Application No: FP/233/20/HH
Site Address: 9 Wansford Way Felpham PO22 7NL
Description of works: Single storey rear extension, first floor side extension and conversion of roofspace to habitable use.

Thank you for your internet representation made on 13th January 2021 which has been recorded as an objection with the comments as follows:

Proposed First Floor Plan

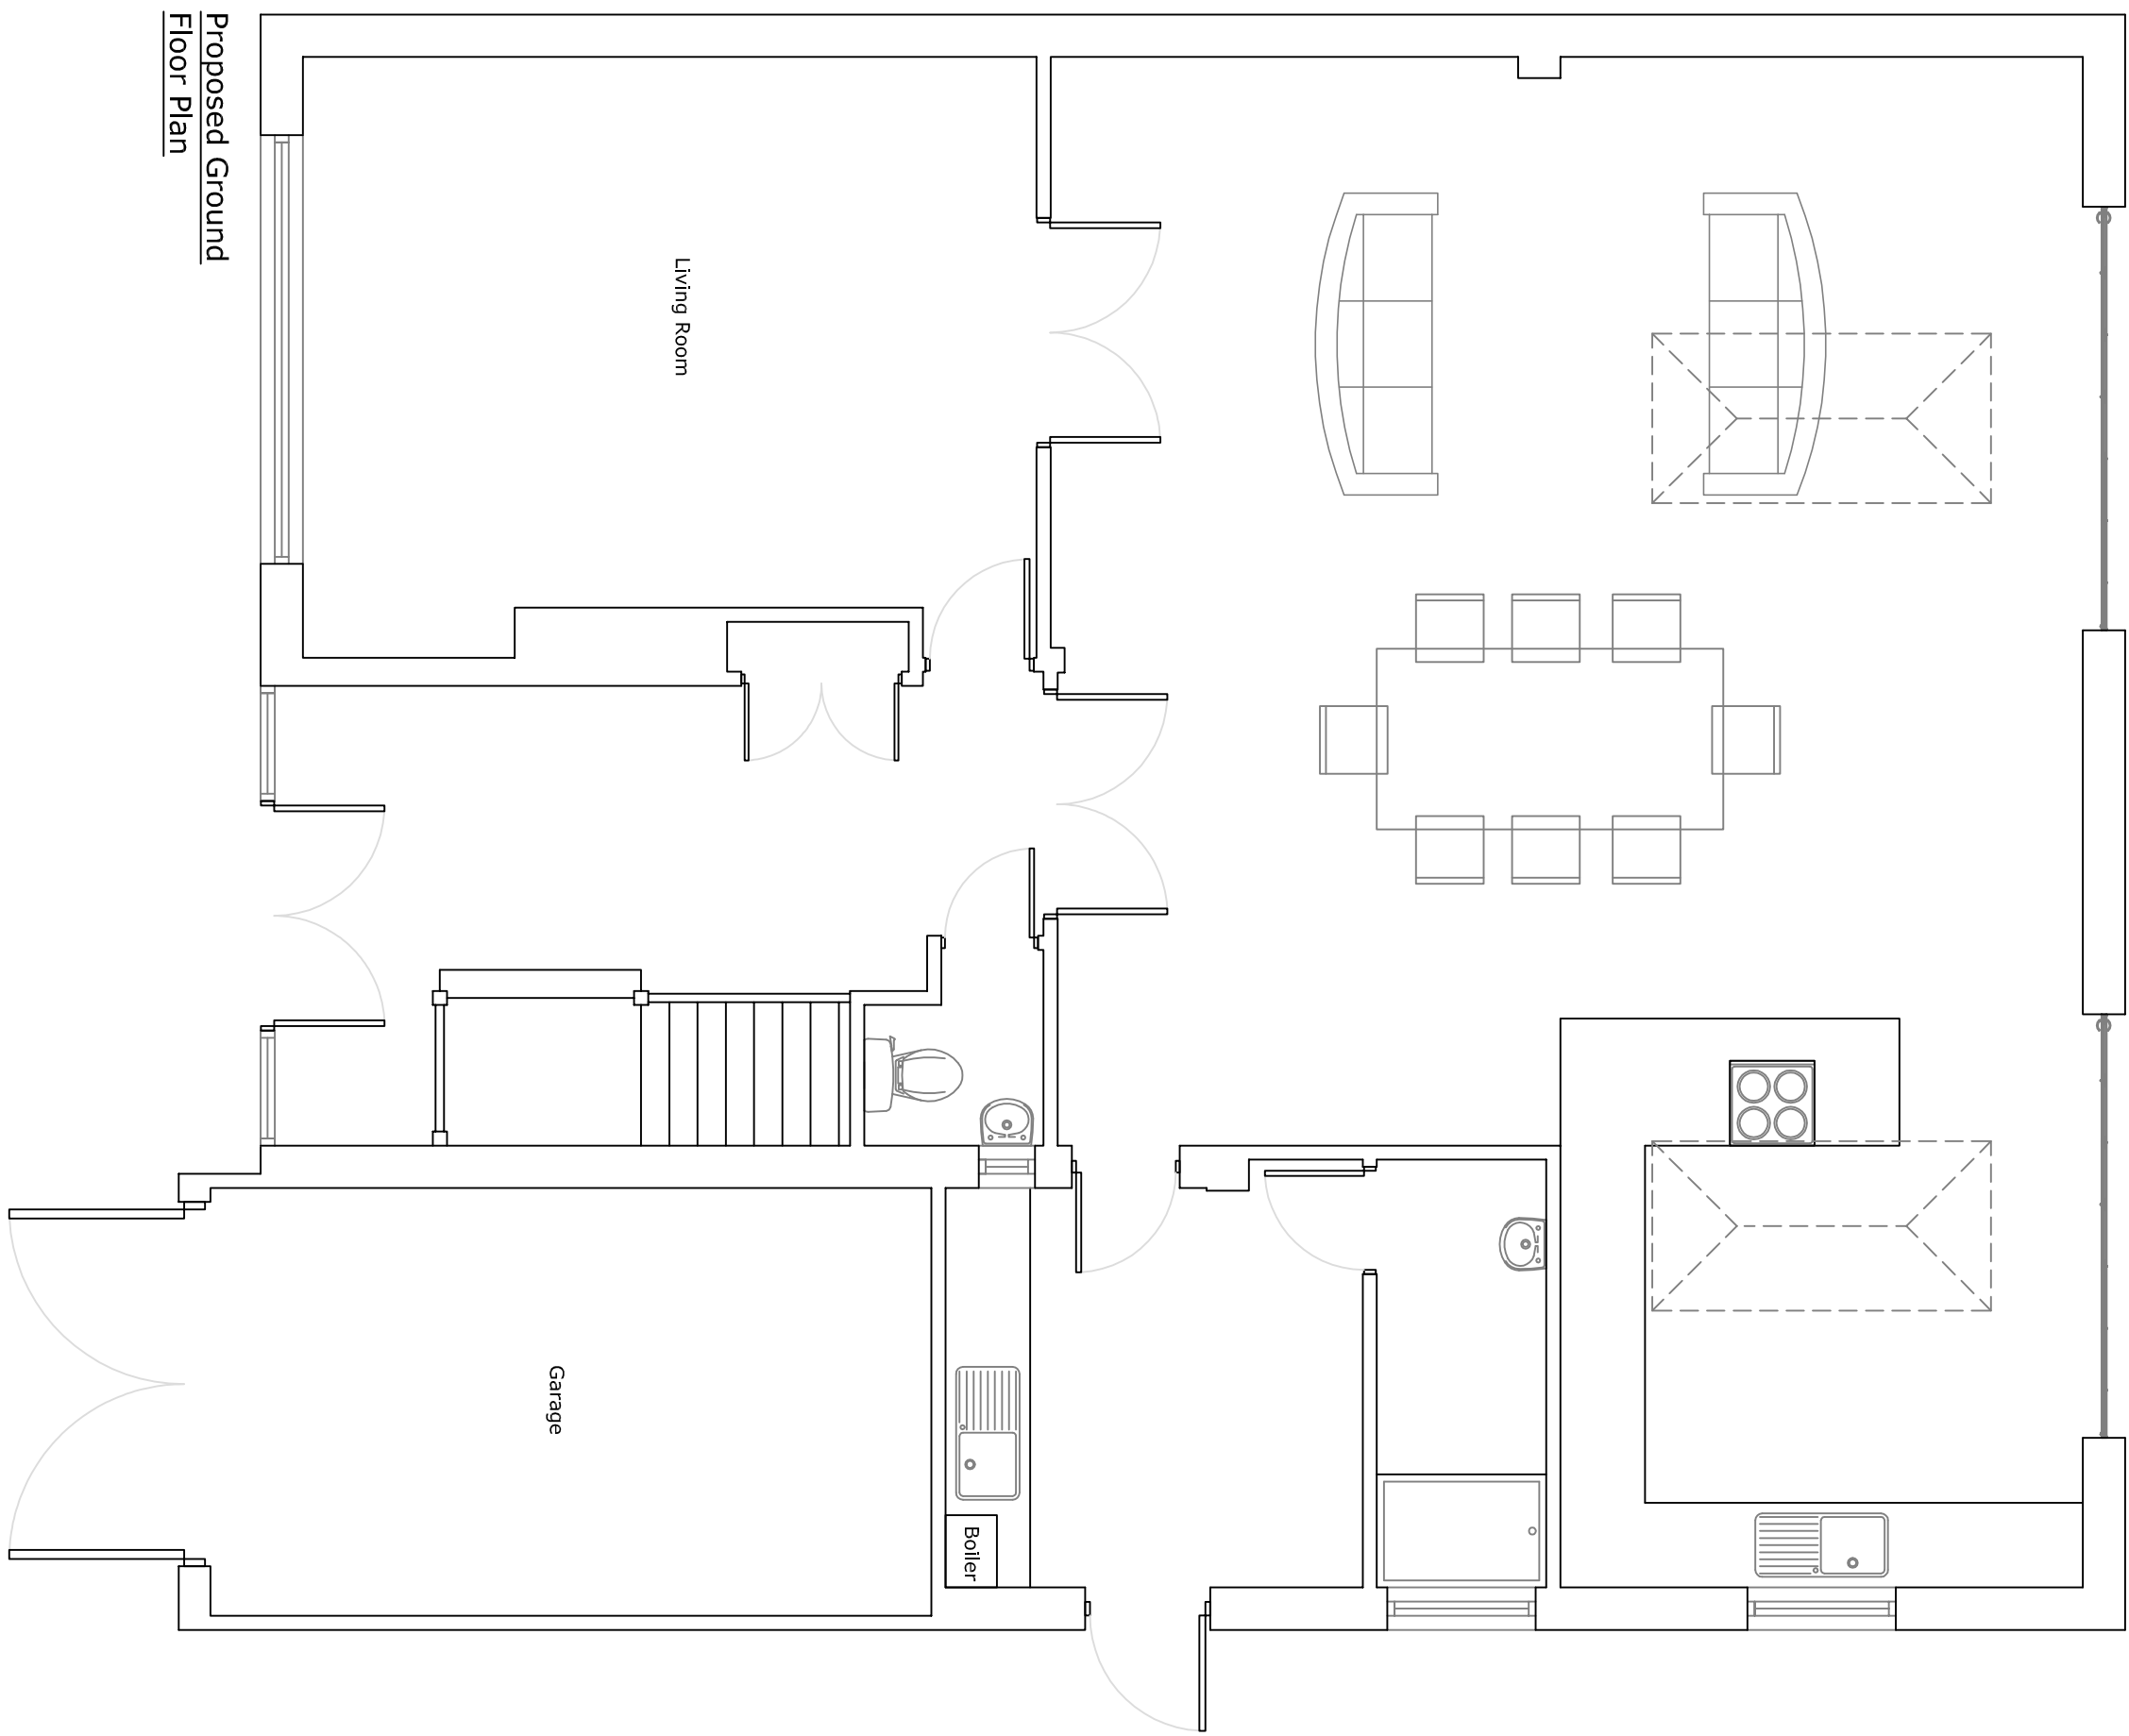
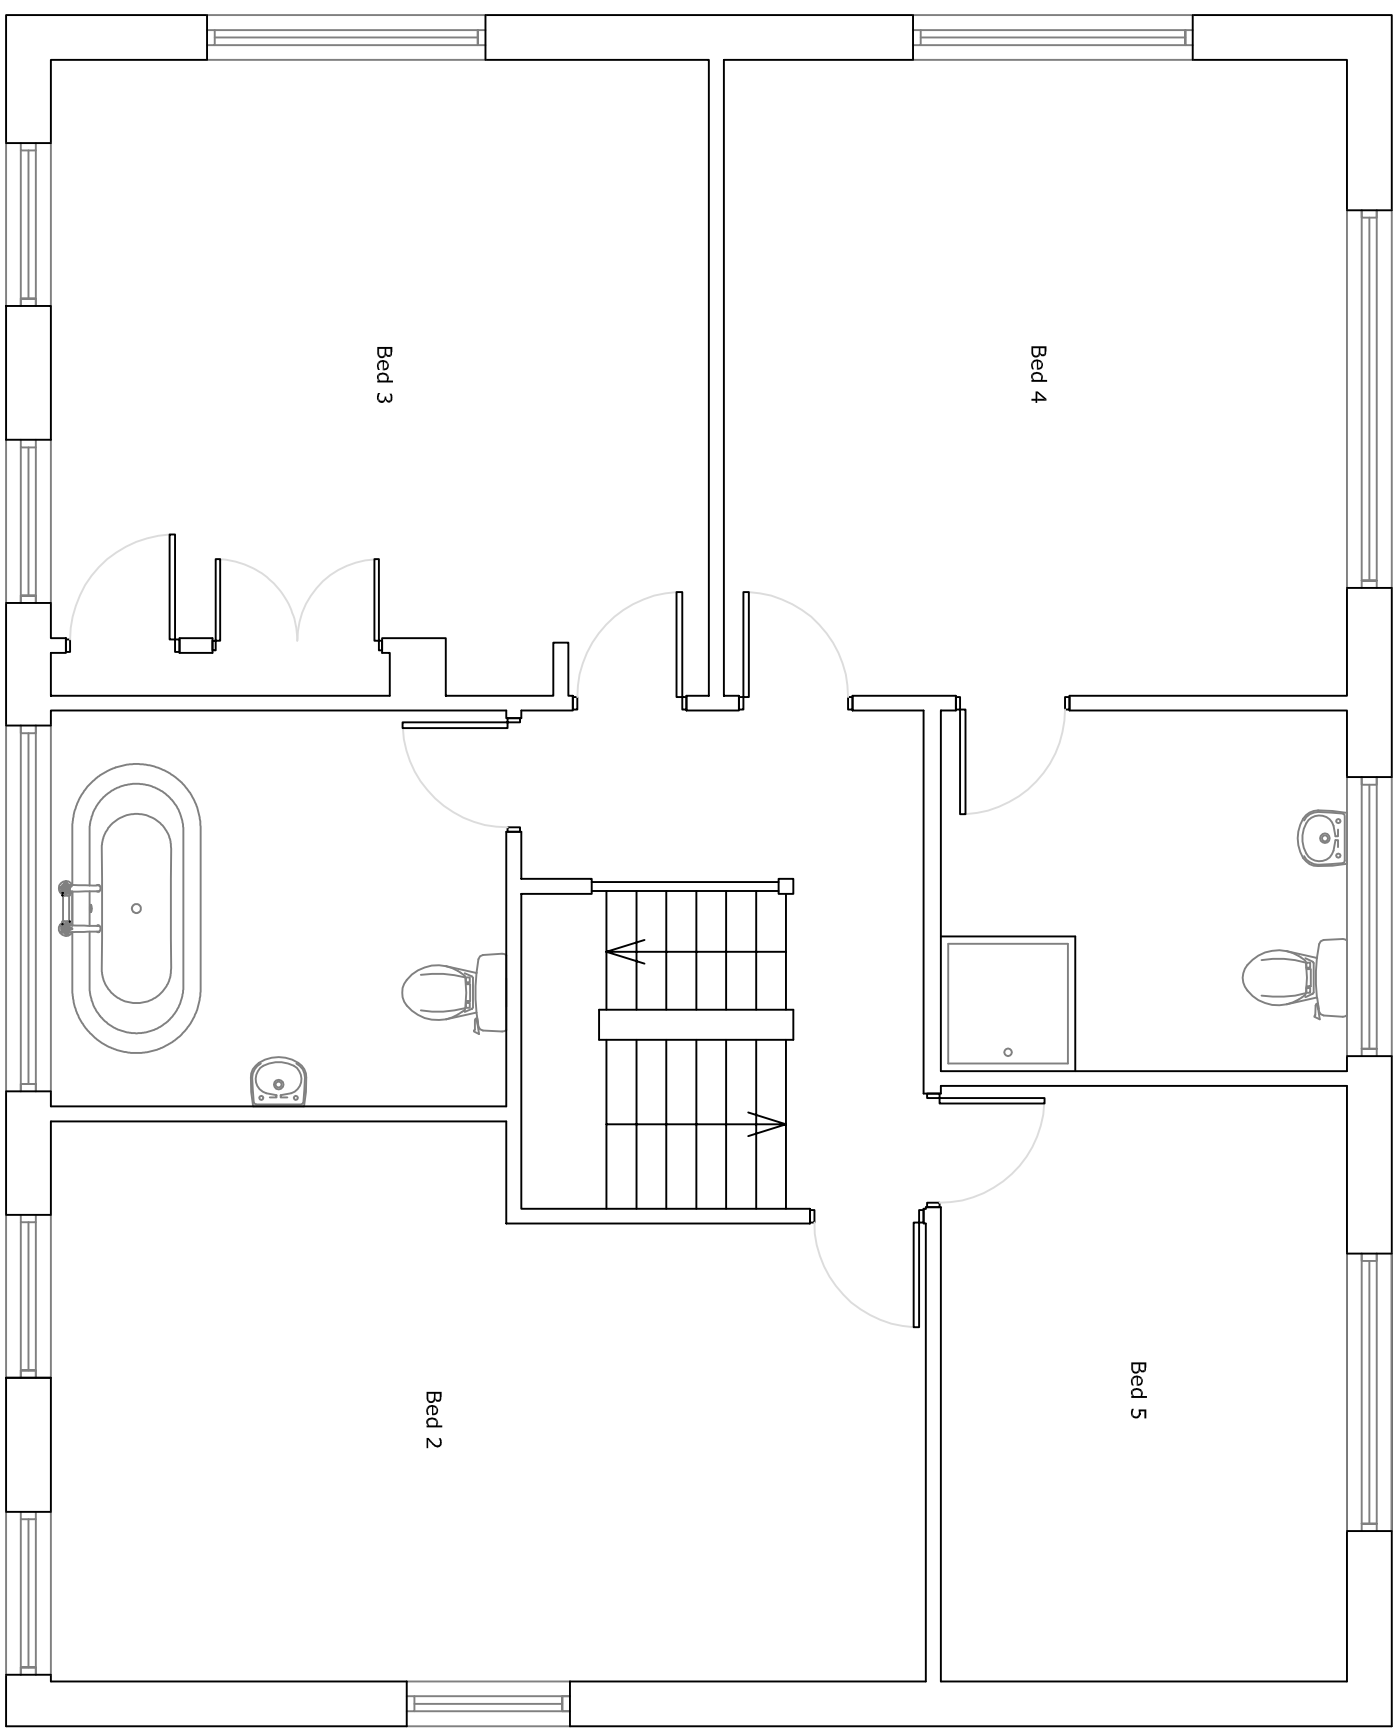
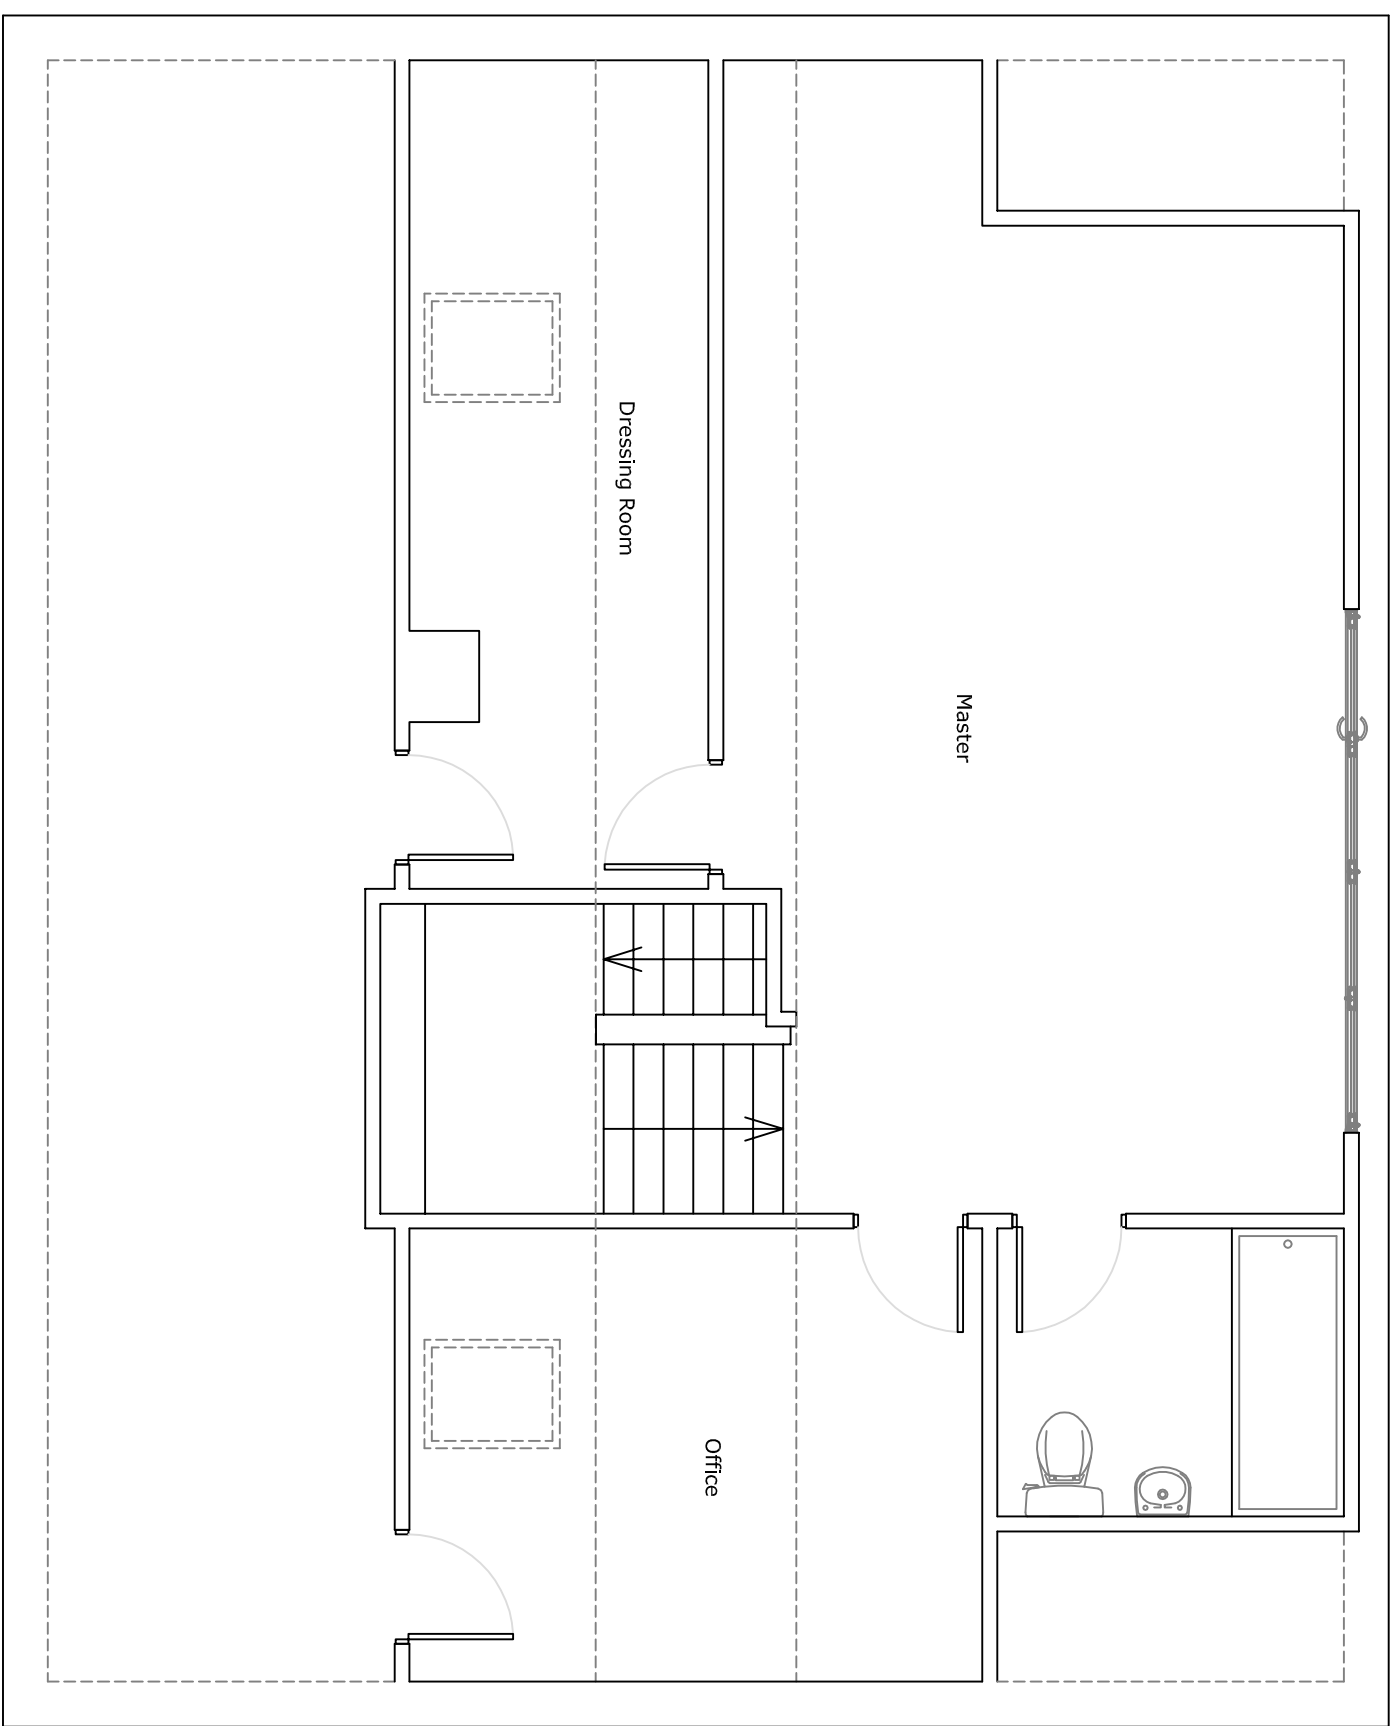
Objection - No location drawing shown and no dimension from proposed 1st Floor extension to boundary of property to ensure that there is a 1m gap at first floor and second floor (roof) level with neighbouring property in accordance with ADC policy DM4.
